CUMBERLAND
CITY COUNCIL

Ref: OA2020/0013

Subject: Request for comments-State Significant Development (SSD)
Application No: SSD-10407
Property: 14 & 16 Kiara Crescent YENNORA NSW 2161
Proposal: Ministerial Consent - Expansion of existing liquid waste treatment facility for increasing processing and storage quantities and hours of operations to 24/7

1 Swept Path 5
1 : 200

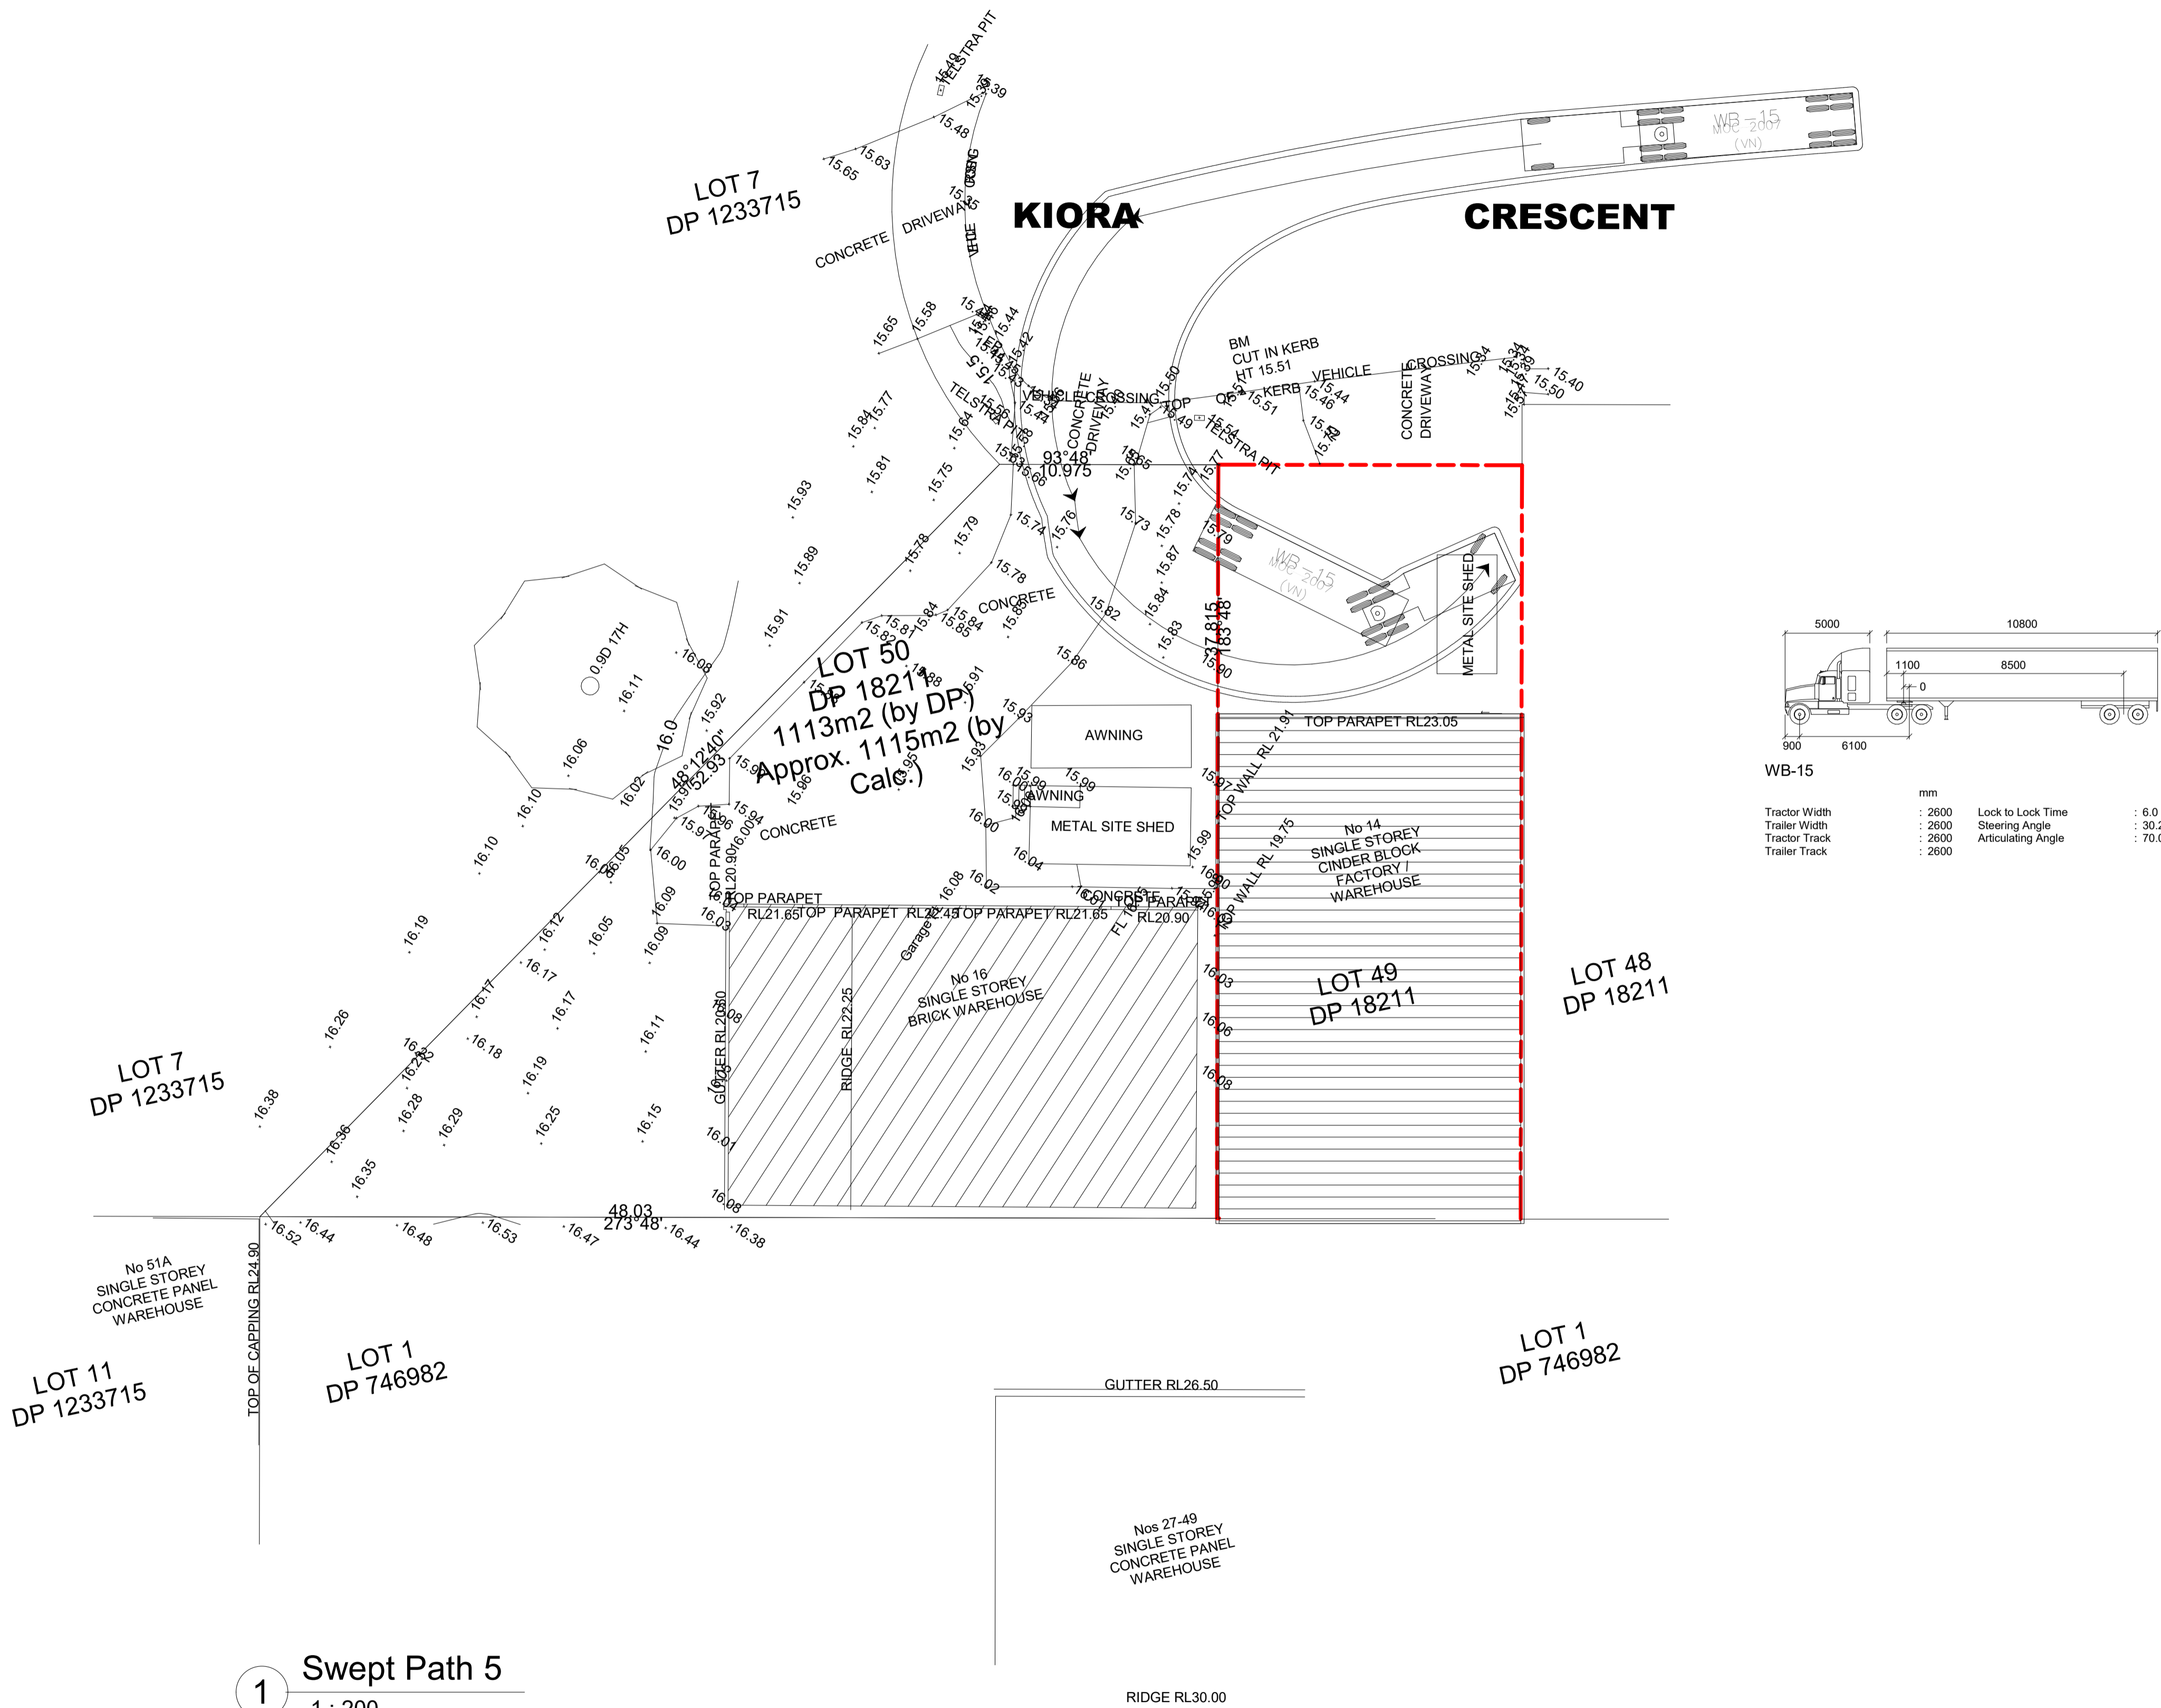
- a) The 10.0m truck used in the swept path analysis is not a standard truck that is defined in Australian standard AS2890.1. Further, the swept path clearance turning with 12,5 standard turning circle must be used.

- b) The manoeuvring and turning of the vehicle must be completed within the site and must not cause encroachment into nature strip or the footpath. The swept path diagrams demonstrate otherwise with the encroachment into nature strip.

- c) Sufficient swept path diagrams must be provided to demonstrate that the turning and manoeuvring of the truck is possible for all, entry and exit for both processing plant. The swept path must demonstrate with a truck in the waiting/stand-by bay.

- d) Further, the Truck swept path diagram also indicates the runover into the structure (entrance door jamb) and the car space for 16 Kiora Place.
- e) Reverse manoeuvring in Council's land is not acceptable. It will compromise the safety. Vehicles should enter and leave the site in a forward direction.

- f) Multiple point turn (more than 3 points) will result in additional time for the turning and manoeuvring thus overlapping with the arrival of another vehicle (truck) and causing obstruction and delay. Enough space must be provided for manoeuvring and turning with the minimum delay. The proposed 4-point turn truck manoeuvring movement is not acceptable. Manoeuvring shall be limited to three-point turn.

- g) Parking and loading design must comply with Australian standard AS2890.1 and AS2890.2. Further the design vehicle into consideration for the swept path analysis must be as per AS2890.2 (not UK standard as noted on the swept path diagram).
- h) The estimated peak hour traffic generation of the waste trucks is based on the assumption that the processing plant is operational 24 hours a day, 7 days a week. However, this is subject to the approval of the proposed operational management plan. Any variation to the operational hours will result in the increase in the frequency of the truck traffic. In such case the following must be complied:
 - (i) The traffic impact report must be revised and demonstrate how this will not result in adverse impact.
 - (ii) Additional facility/ area for holding the waste
 - (iii) Additional facility/area for the trucks waiting for unloading the waste.
